Consultation Response from KC, Highways Development Management
2025/92323 44, Fall Lane, Hartshead, Liversedge, WF15 8AR
Demolition of existing garage and erection of replacement detached garage and two storey side extension
Date Responded: 03/02/2026 Responding Officer: D. Stainsby Responding Ref: K10-4/6

title: SITE PLAN

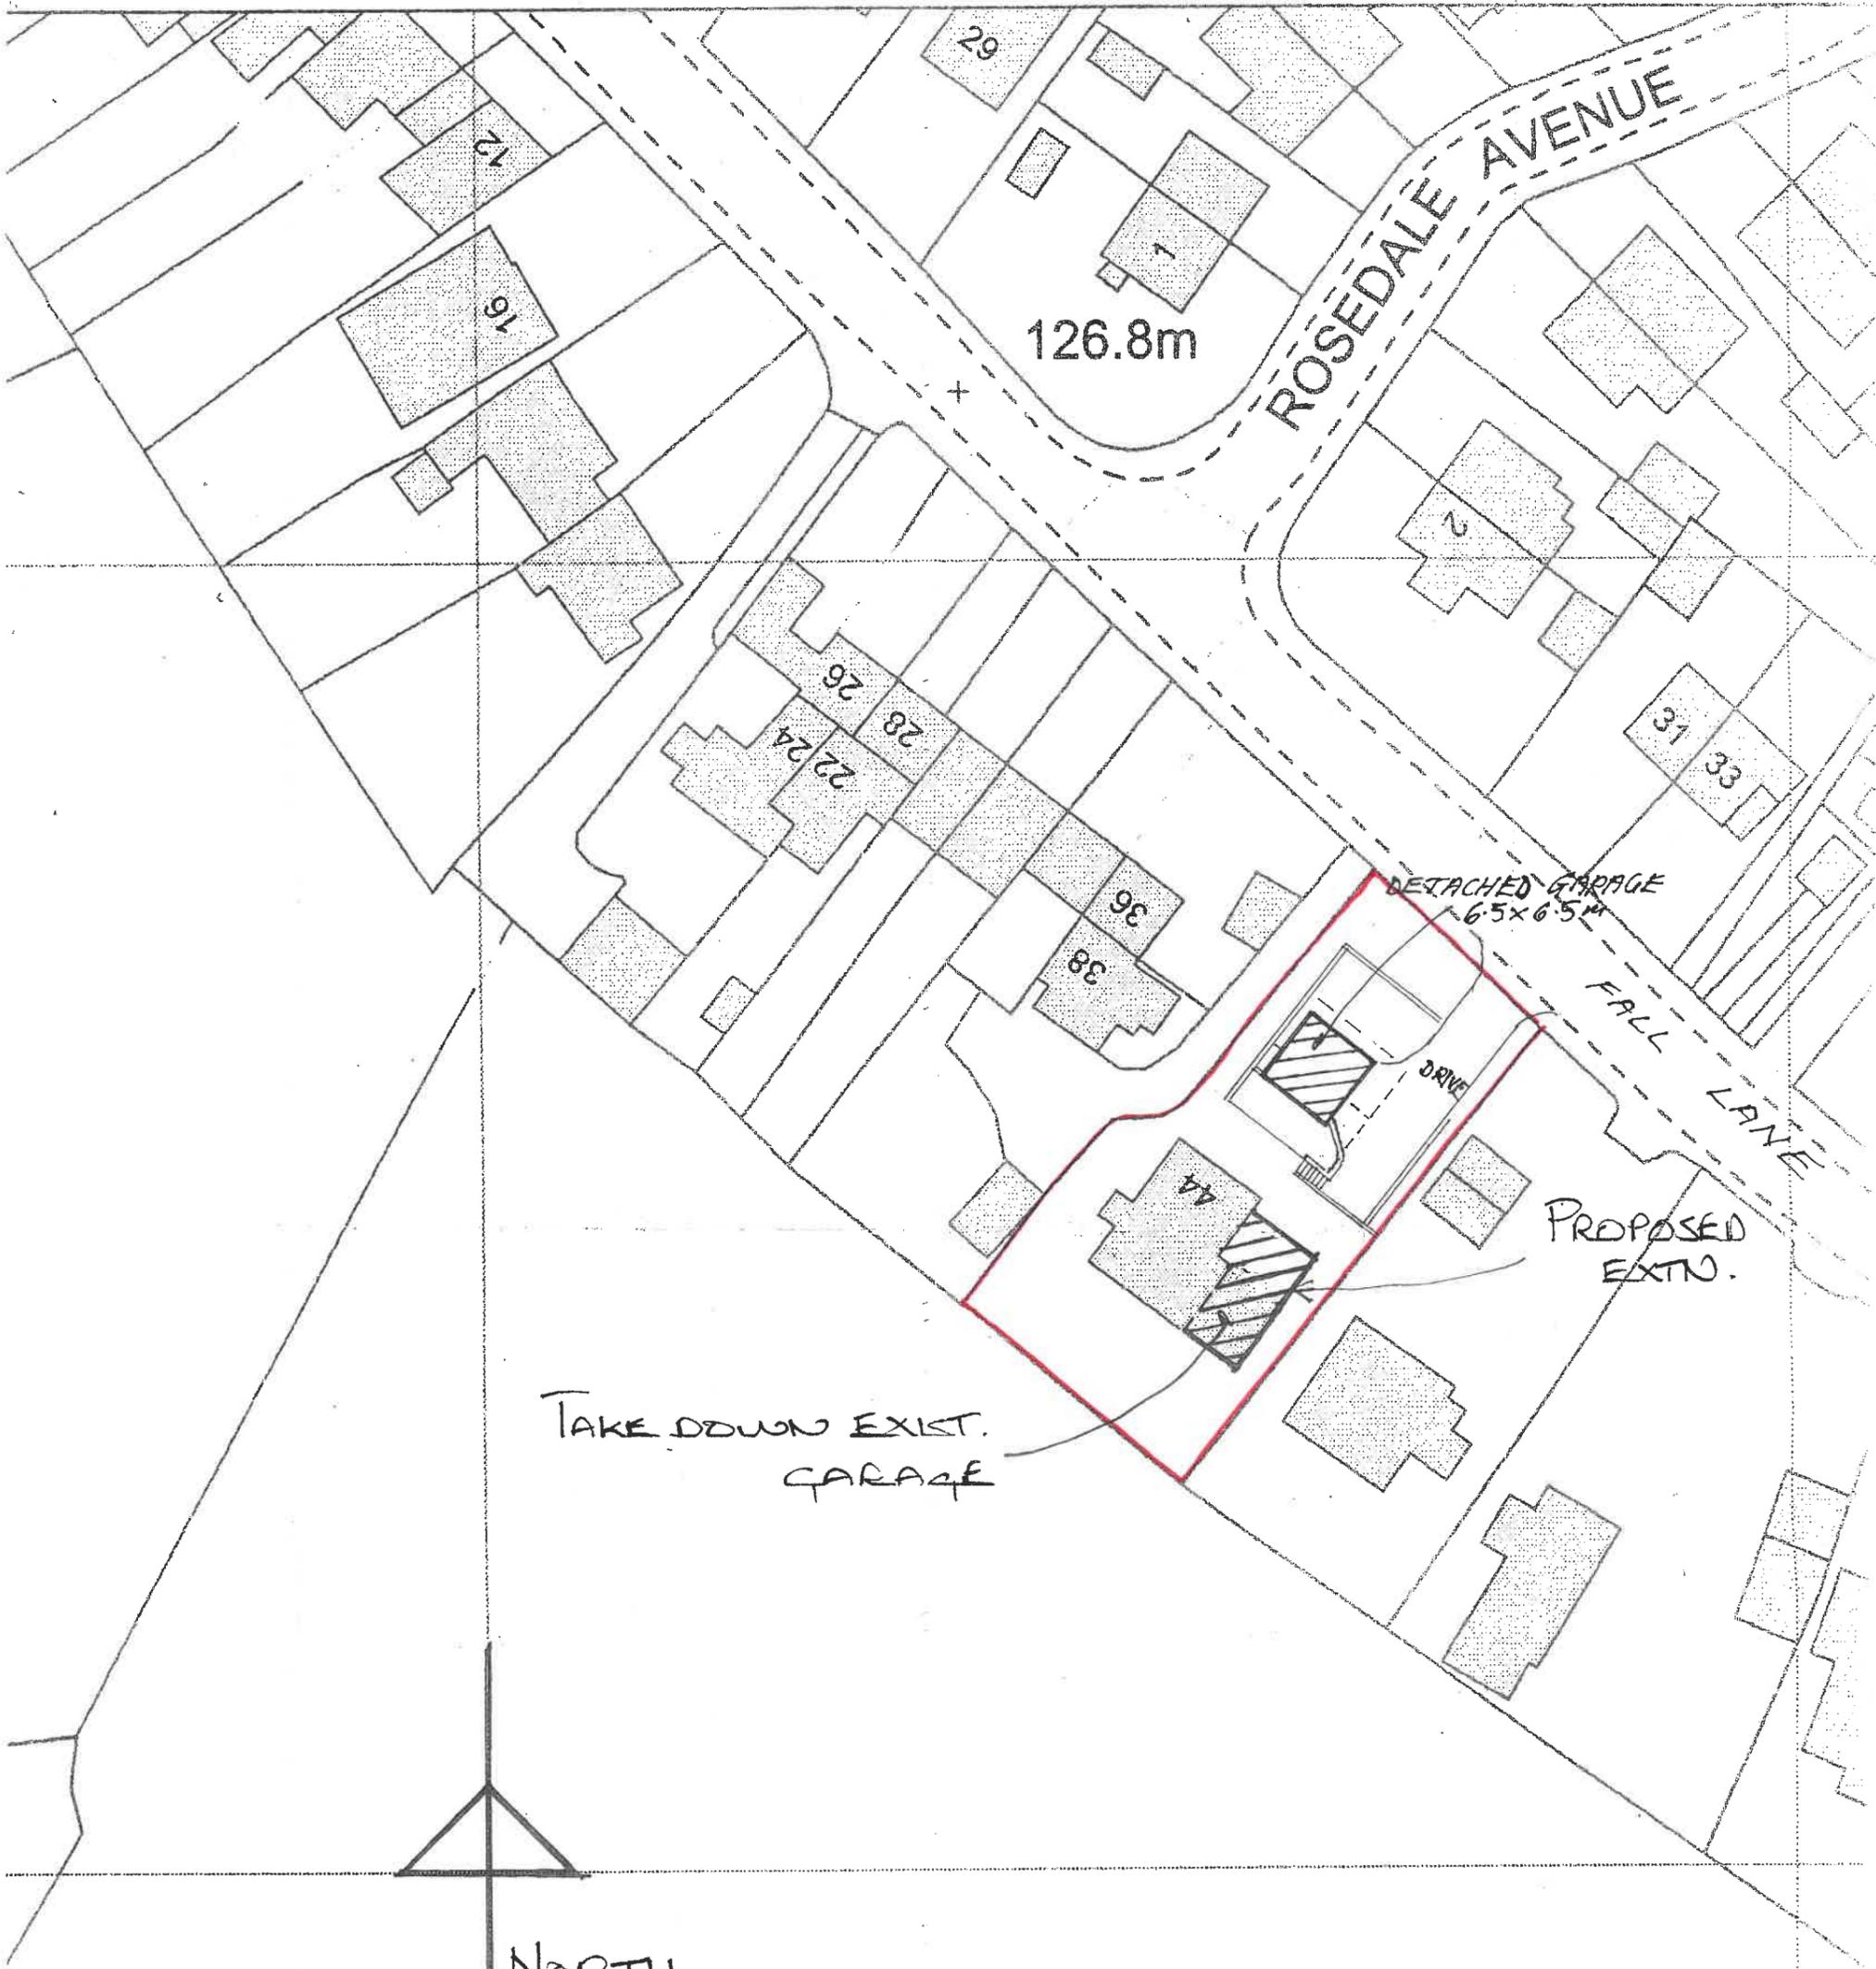
The application site is located off Fall Lane and access will remain as existing.

Given that this is a replacement garage and sufficient off-street parking is shown to be retained Highways Development Management have no objection to these proposals.

The approved vehicle parking areas will need to be surfaced and drained in accordance with the Communities and Local Government; and Environment Agencies 'Guidance on the permeable surfacing of front gardens (parking areas)' published 13th May 2009 (ISBN 9781409804864) as amended or superseded.
